Comment for planning application 22/01144/F

Application Number	22/01144/F
Location	OS Parcel 5700 South West Of Grange Farm Street Through Little Chesterton Chesterton
Proposal	Full planning application for the erection of a new high quality combined research, development and production facility comprising of Class B2 floorspace and ancillary office floorspace with associated infrastructure including: formation of signal-controlled vehicular access to the A41 and repositioning of existing bus stops; ancillary workshops; staff gym and canteen; security gate house; a building for use as an energy centre (details of the energy generation reserved for future approval); loading bays; service yard; waste management area; external plant; vehicle parking; landscaping including permanent landscaped mounds; sustainable drainage details; together with the demolition of existing agricultural buildings within the red line boundary; and the realignment of an existing watercourse.

Title  
**PROPOSED CULVERTED WATERCOURSE DETAILS.**

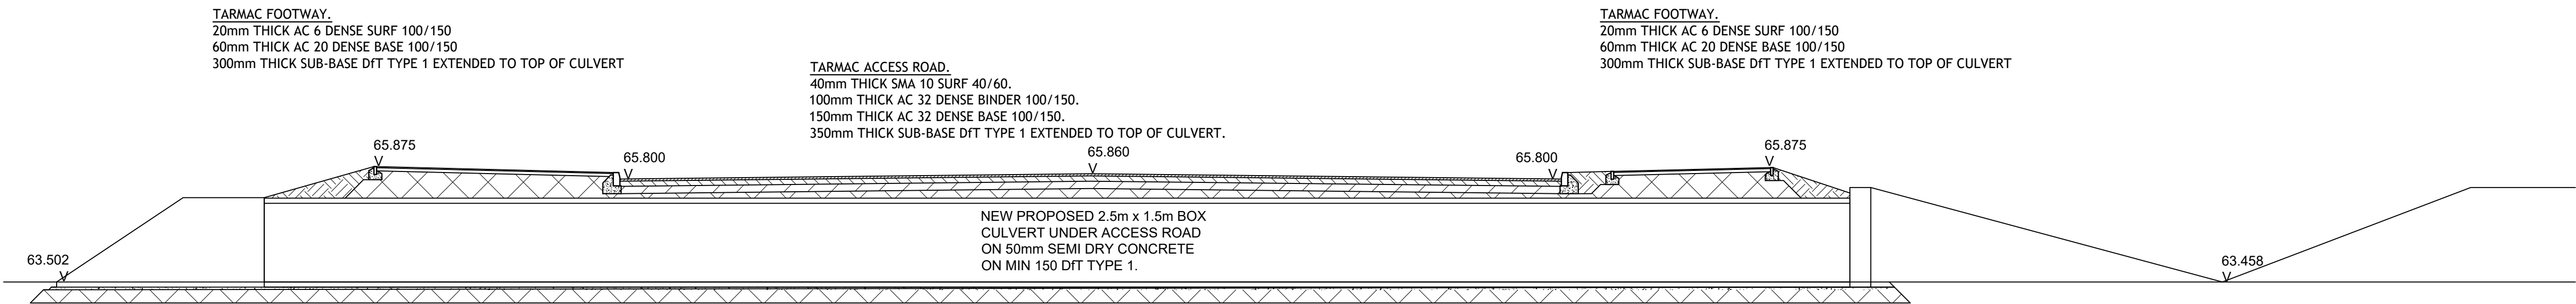
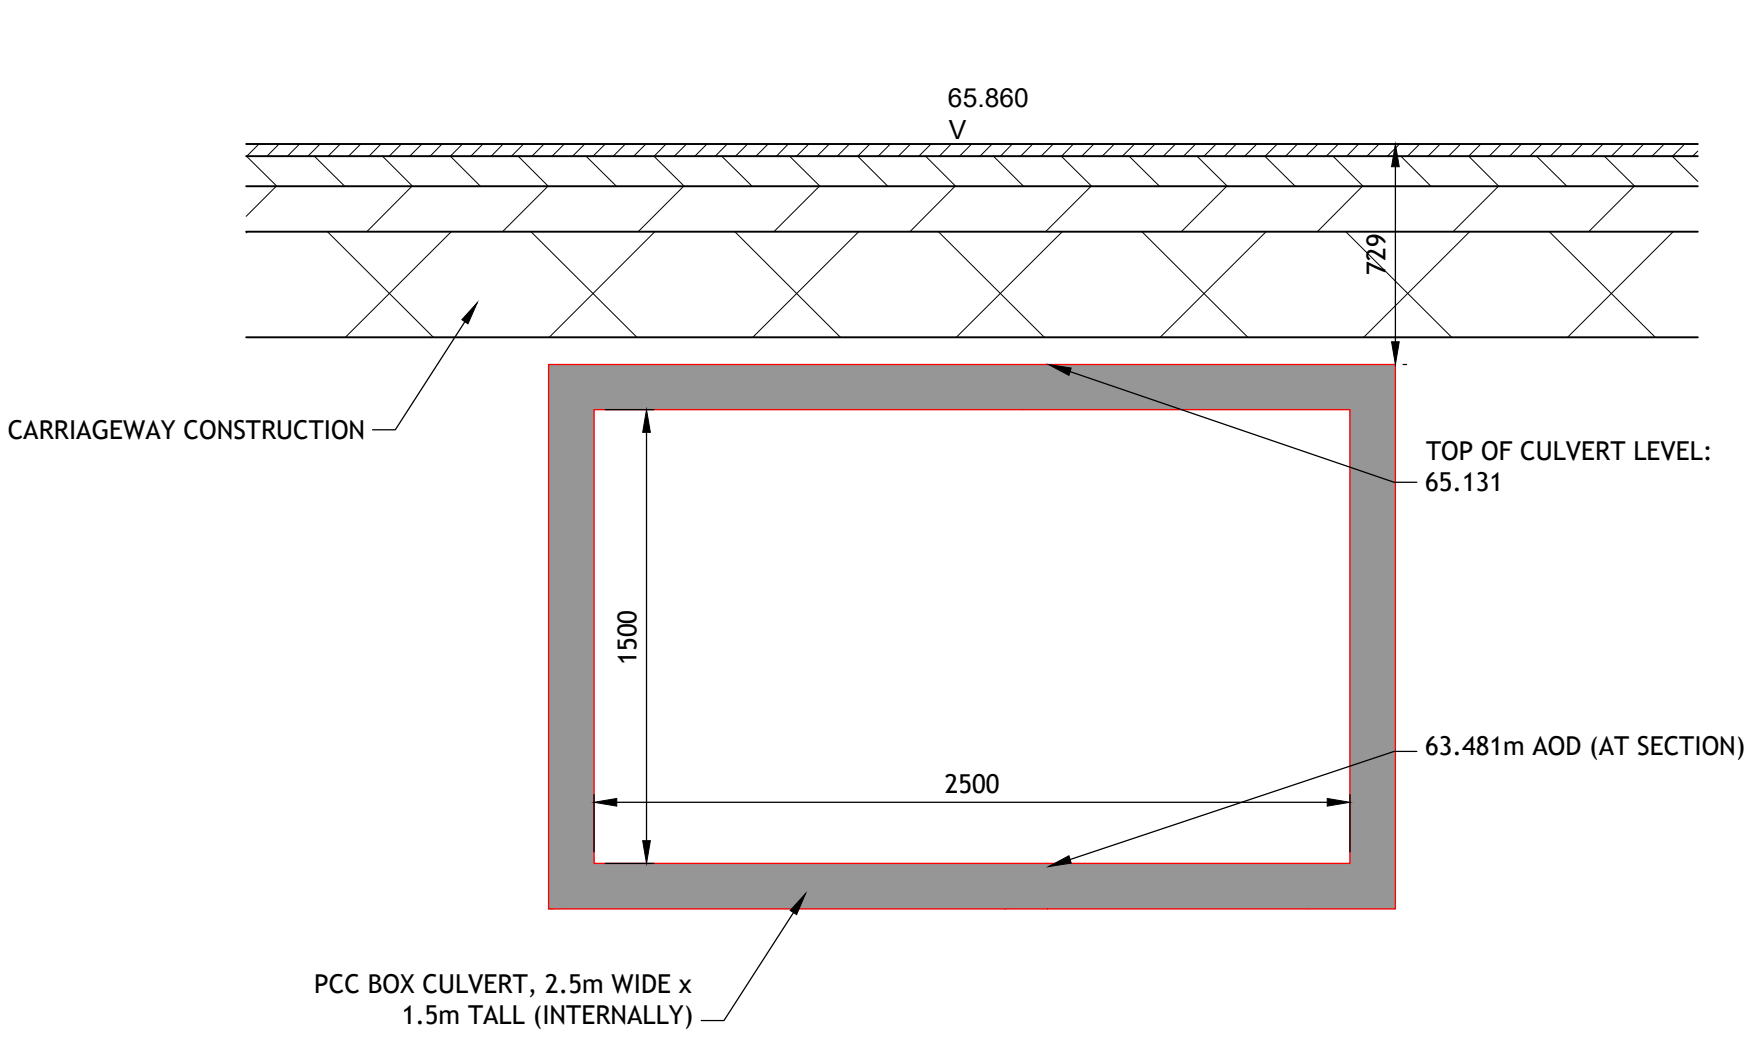
Case Officer	Robin Forrester
Organisation	
Name	Jackie Hucker
Address	14 Rectory Close,Wendlebury,Bicester,OX25 2PG
Type of Comment	Comment
Type	neighbour
Comments	I wish to comment on this planning application on the following grounds: 1 The realignment of an existing water course. The Brook that flows from Little Chesterton to Wendlebury is already known to flood and 1 1 Wendlebury has been affected by flooding in both properties and gardens. On occasions Wendlebury itself has been impassable due to the flooding to both residential properties and businesses. Cherwell has not previously responded to appeals for the brook to be realigned despite risk to peoples homes. 2 Moving the existing bus stops. People travelling from Oxford to Bicester who alight the bus at the Wendlebury Turn bus stop already dice with death crossing the road where the bus stop is currently, moving the bus stops will mean that pedestrians are put at more risk. This is an unlit road which makes crossing near to the village treacherous as it is. 3 If erecting traffic lights and pedestrian crossings the speed on the A41 will need to be reduced as it is currently 70 mph in some places. When traffic is backed up there will be rat running through Wendlebury where there are no street lights, a 20mph speed limit and no pavements. It would be very helpful if the council could consider and take into account the views of people living in the village. Thank you
